KIRKLEES METROPOLITAN COUNCIL INVESTMENT & REGENERATION SERVICE

DELEGATED DECISION TO DETERMINE PLANNING APPLICATIONS

Reference No:	2023/62/93420/E
Site Address:	33, Ravens Crescent, Scout Hill, Dewsbury, WF13 3QG
Description:	Erection of single storey rear extension, porch to front, dormer window with hip to gable wall
Recommending Officer:	Elenya Jackson

DECISION – Conditional Full Permission

PROPOSED
ROOF PLAN

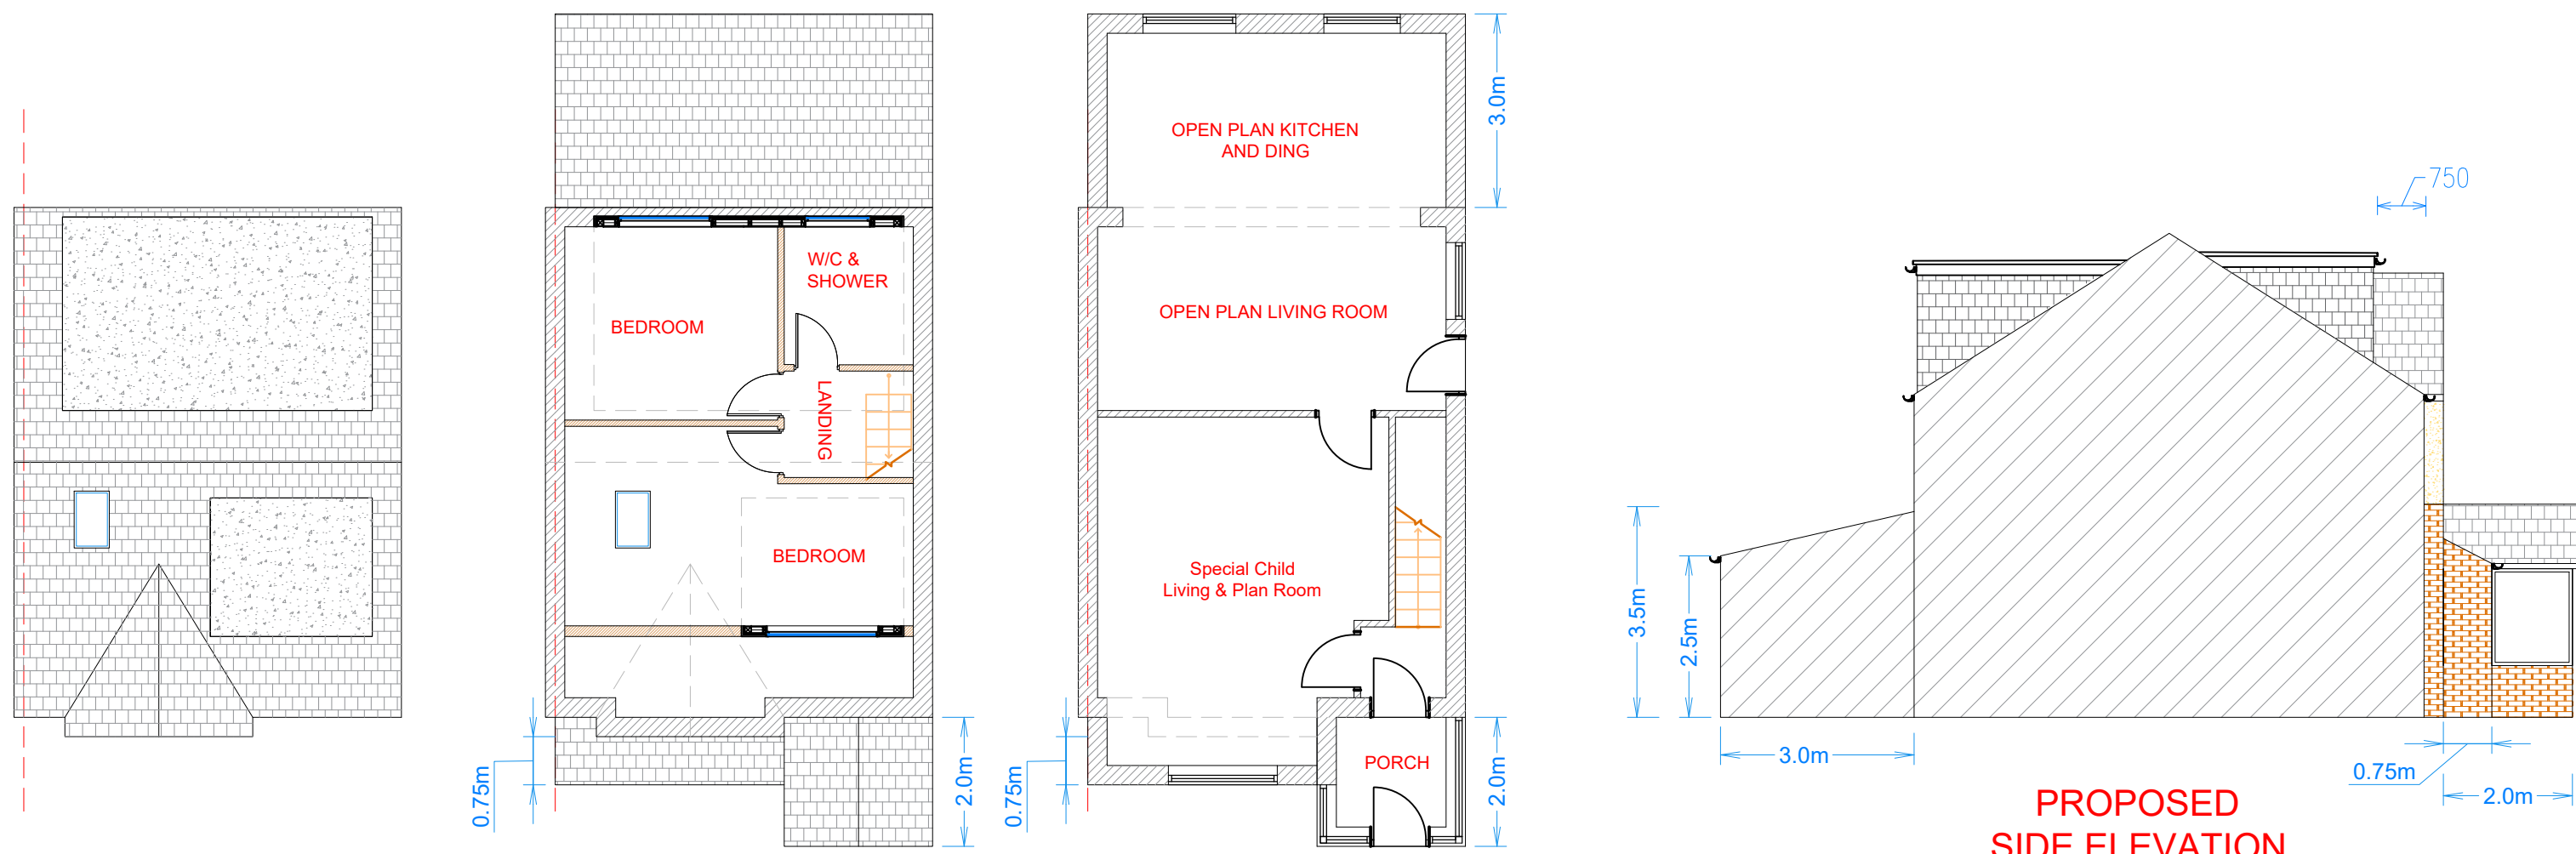
The applicant was initially seeking permission for the erection of single storey rear extension, porch to front, dormer windows with hip to gable wall. However, following concerns raised by officers, the front dormer has been removed from the proposals.

consideration. The removal of the front dormer was requested by officers through the course of the application.

Section 5.4 of the HEASPD refers to dormer windows and roof alterations. It is acknowledged the front dormer and a portion of the rear dormer could not be built without the alteration of the existing roof from a hip to gable.

It is considered that despite the majority of the street scene being comprised of hipped roofs, the adjoining neighbour of the application property and the adjacent property to the rear have already constructed a hip to gable alteration. The initially proposed front dormer has been removed and replaced

with a roof light and the rear facing dormer would be in-keeping with other dormers in the vicinity.

4. The rear dormer hereby approved shall be faced in tiles to match the colour of the existing roof.

The agent was requested to remove the proposed dormer from the principal elevation of the dwelling. These alterations were made and the application progressed accordingly.

PROPOSED
FRONT ELEVATION

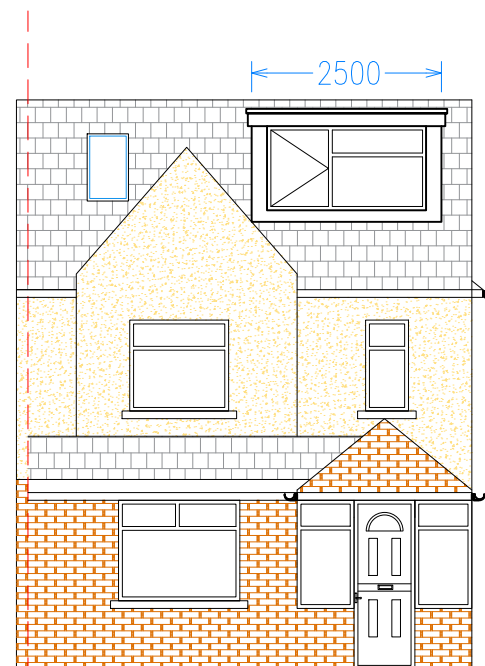
The proposed porch would extend 2m beyond the front elevation of the dwelling towards the west and 0.75m beyond the front elevation towards the north.

Officers consider that the limited projection of the single storey front extension when coupled with its matching materials would result in the proposal adhering to section 5.2 of the HEASPD.

PROPOSED
REAR ELEVATION

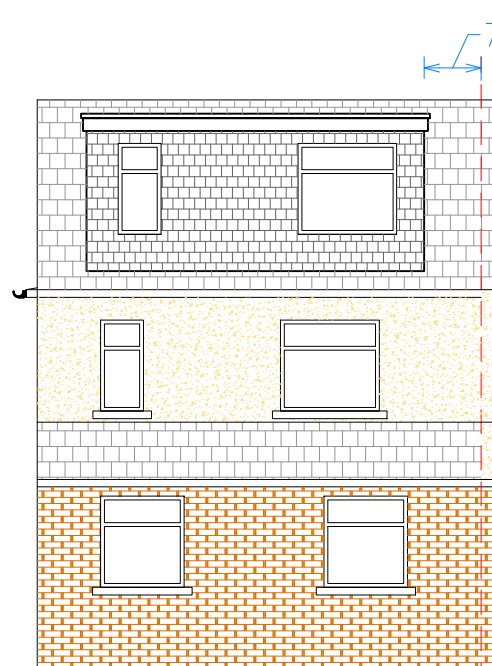
The rear dormer would have a width of 4.4m, a height of 2m and a projection of 3.2m.

The single storey rear extension would extend 3m beyond the rear elevation of the existing dwelling, would have an eaves of 2.5m and a maximum height of 3.5m. The single storey rear extension would not be set 1m off of the shared boundary; however, the adjoining neighbouring has a two storey rear extension on the shared boundary. Therefore, the proposal would be considered to accord with section 5.1 of the HEASPD.

Overlooking: the proposal would introduce rear facing windows into the roof of the application property. No.35 has two first floor side facing windows, one of these is obscured. It is considered that rear facing windows in the application property are an established relationship between the dwellings and the windows would be offset from the rear dormer. Therefore, no significant issues would arise regarding overlooking.

Overshadowing/loss of light/overbearing: the proposed rear alterations would be for a single storey rear extension and a dormer that does not extend above the ridge of the existing dwelling. Therefore, no significant issues would arise regarding overshadowing/loss of light/overbearing.
